Feedback on REP3-065 Written Summary of Applicant's Oral Submissions at the Issue Specific Hearing 2 (ISH2) Document Reference: EN010159/APP/9.22

Viewpoint 9b View from Moor Farm on public bridleway (NT/North Clifton/BW10) (Winter)

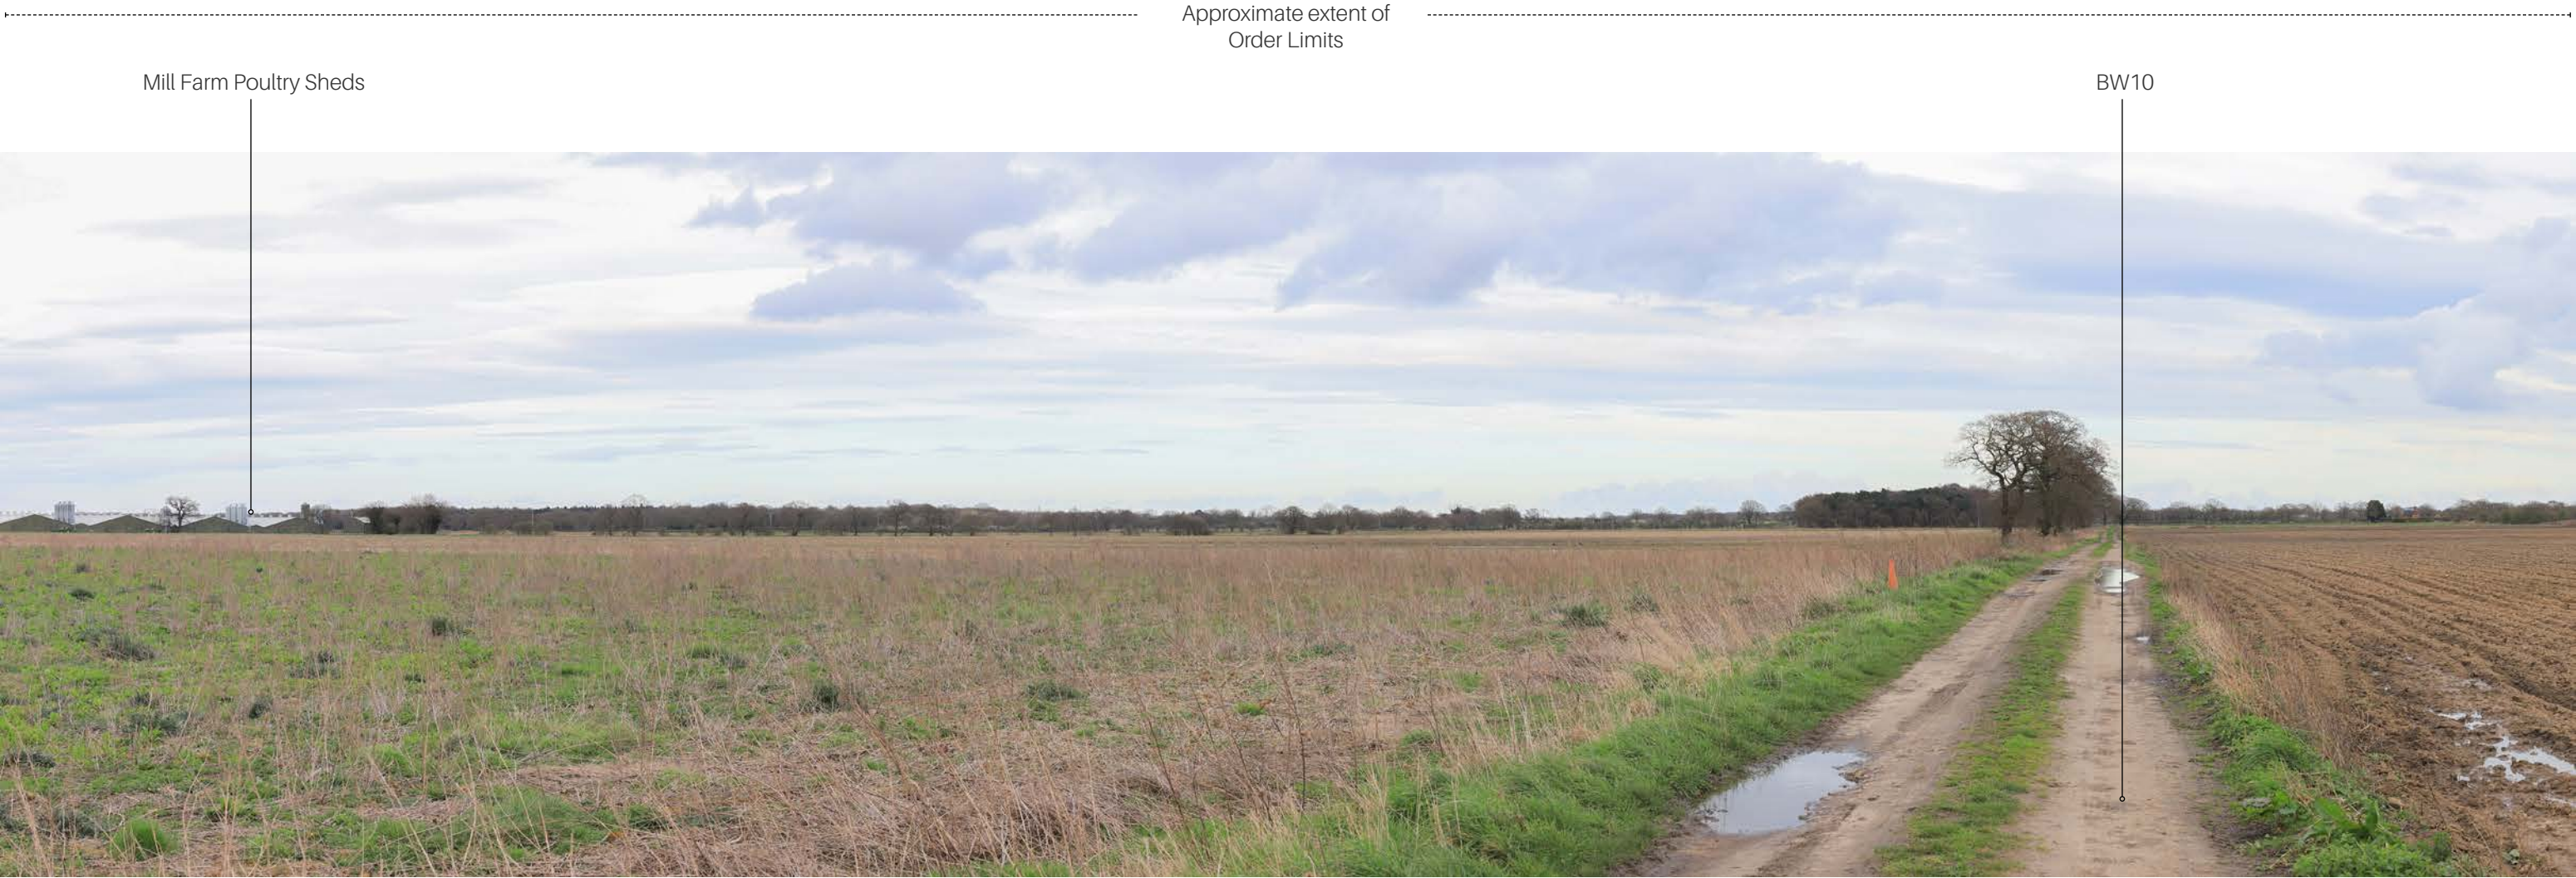
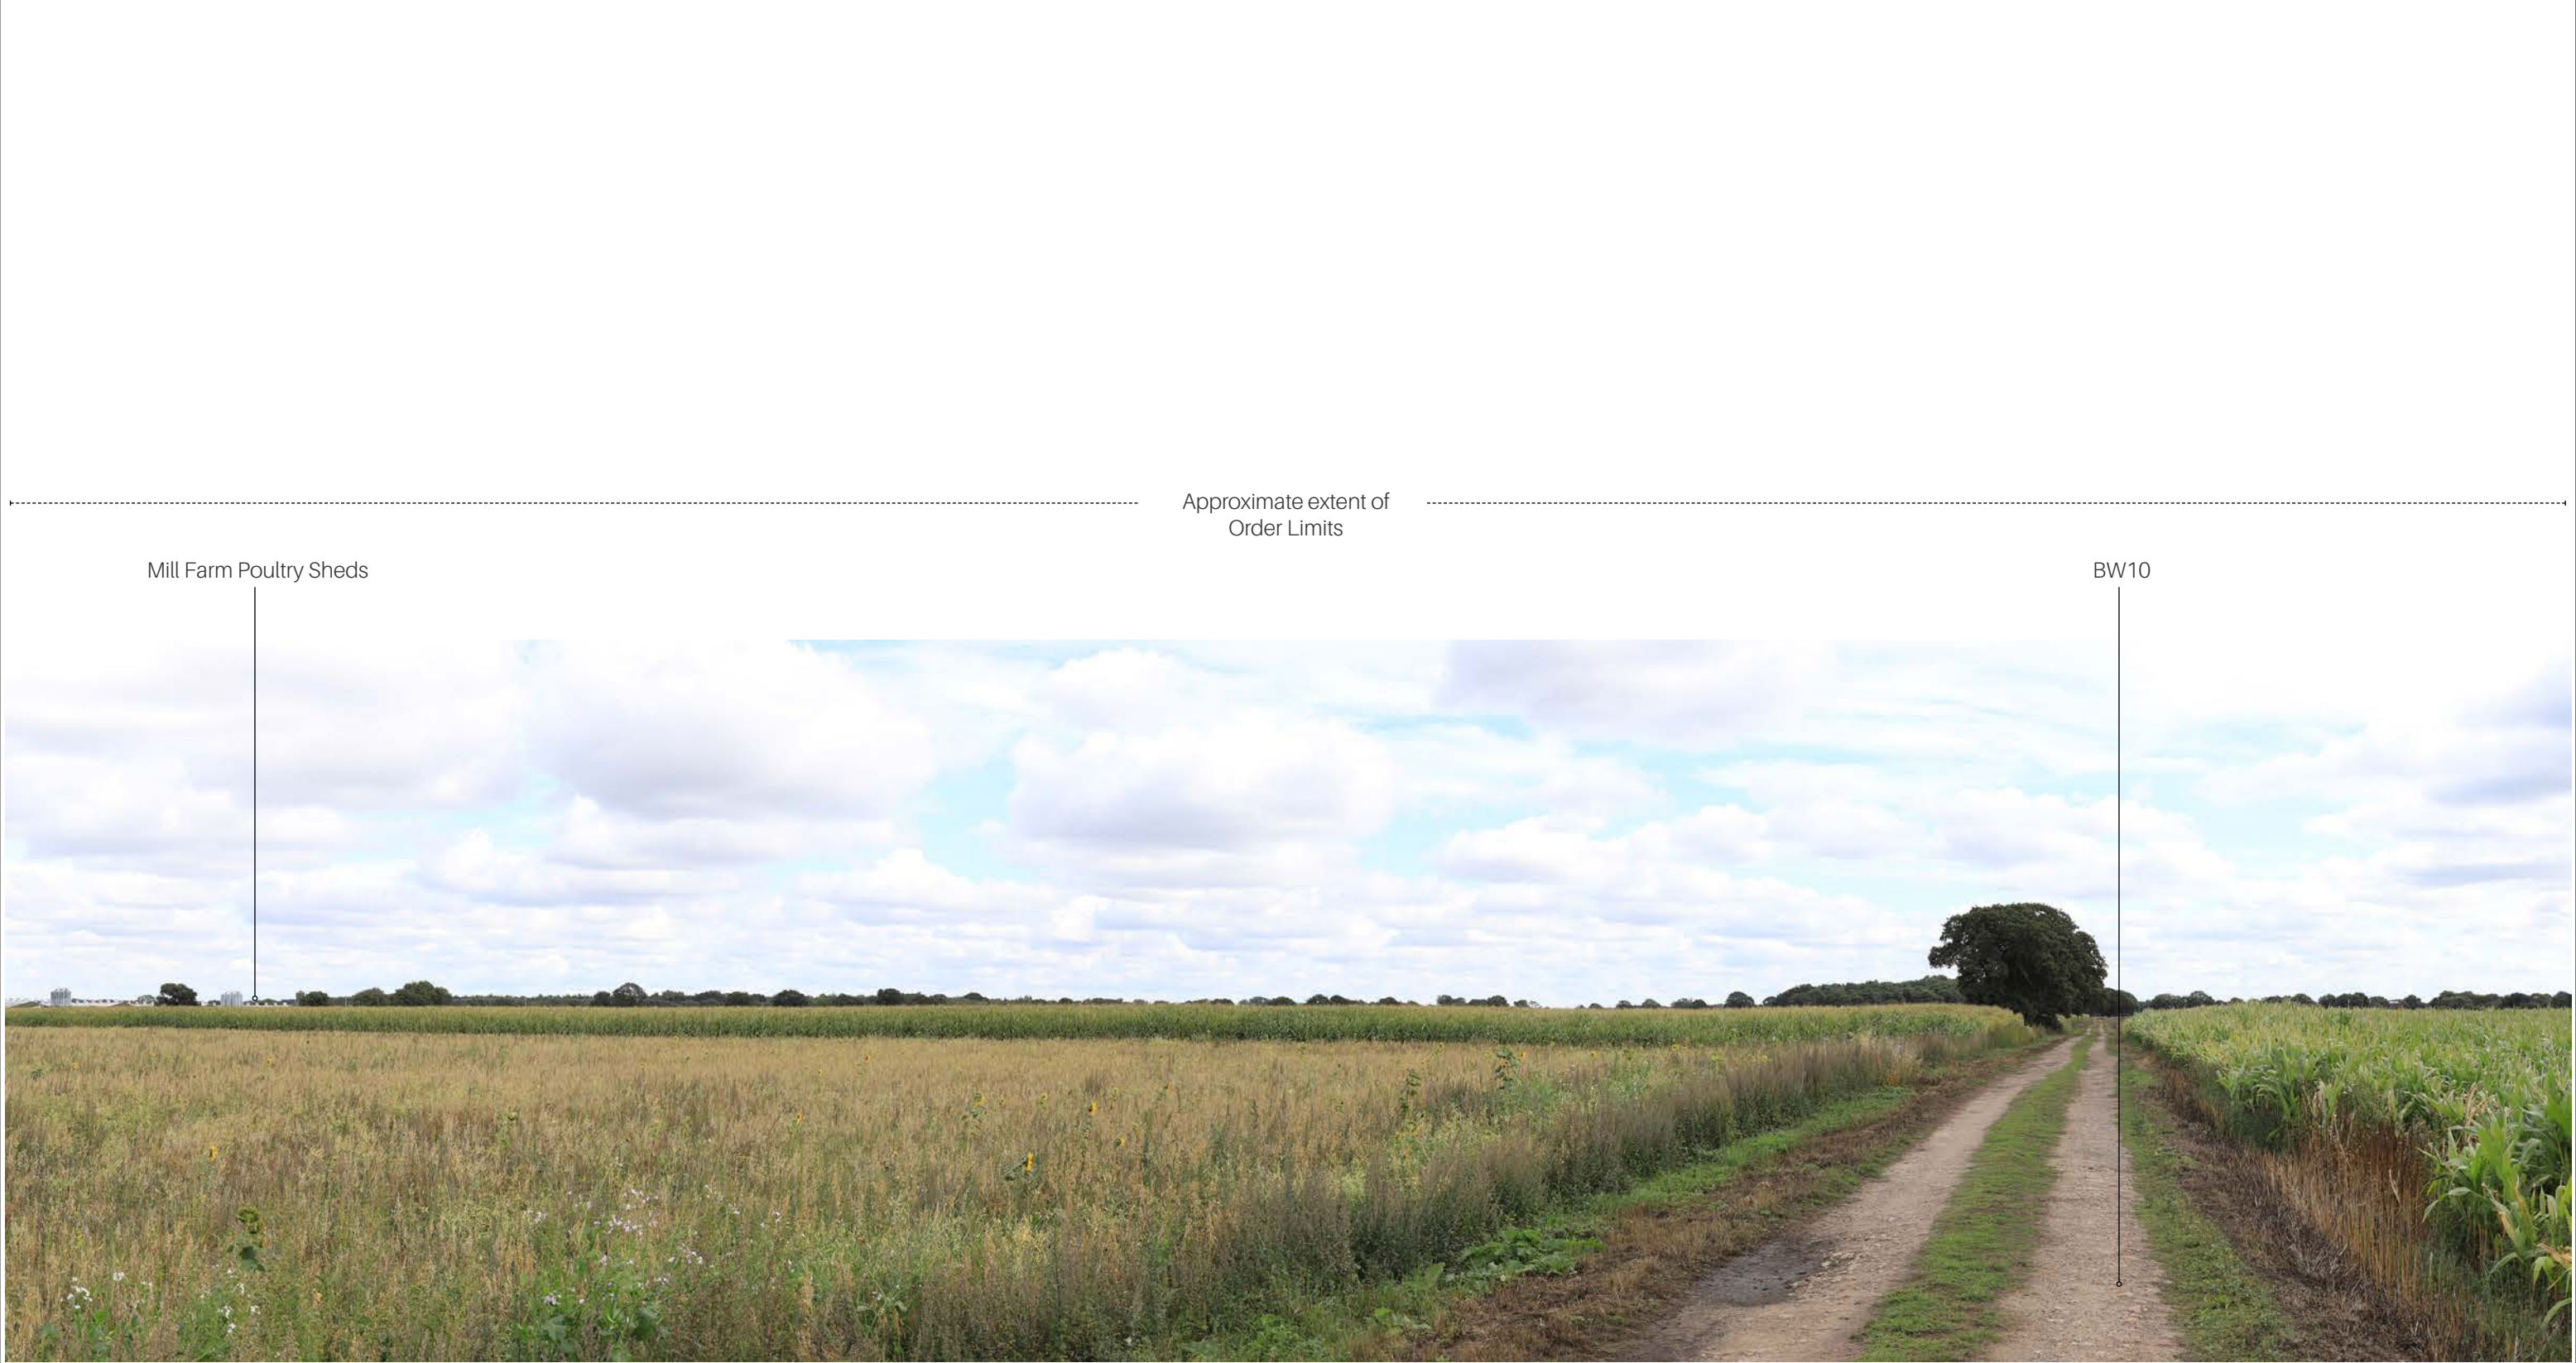
I would like to point out the information provide by the Applicant to demonstrate the accuracy of their photomontages appears to still be misrepresentative of the site. I refer the ExA to Viewpoint 9 Part B on Page 59 of the pdf document. The Applicant has added a person at 1.5m and a 3.5m ruler along the fence line. If you zoom in to view this up close the solar panels do not appear to be as high as the 3.5m ruler, despite the panels in this area being 3.5m nearest to the fencing viewable in the below picture and then raising to 3.8m high. There is no visibility of higher panels in the background of the picture where they should be 3.8m.

There is also misrepresentation of the PCS units which are planned to be 6m high due to this area being within a flood zone, yet when you refer to the photomontage of Viewpoint 9 Part B, the PCS unit container appears to be barely higher than the 3.5m solar panels or the 3.5m ruler.

As demonstrated by Mr Walker and the mock solar panel during the ExA site visit to Moor Farm, North Clifton and the above addition of a 3.5m ruler by the Applicant, the photomontages submitted by the Applicant are not accurately representative of what the landscape will look like. If the above is showing this information to be a misrepresentation, then it could be assumed other photomontages are also likely not accurate.
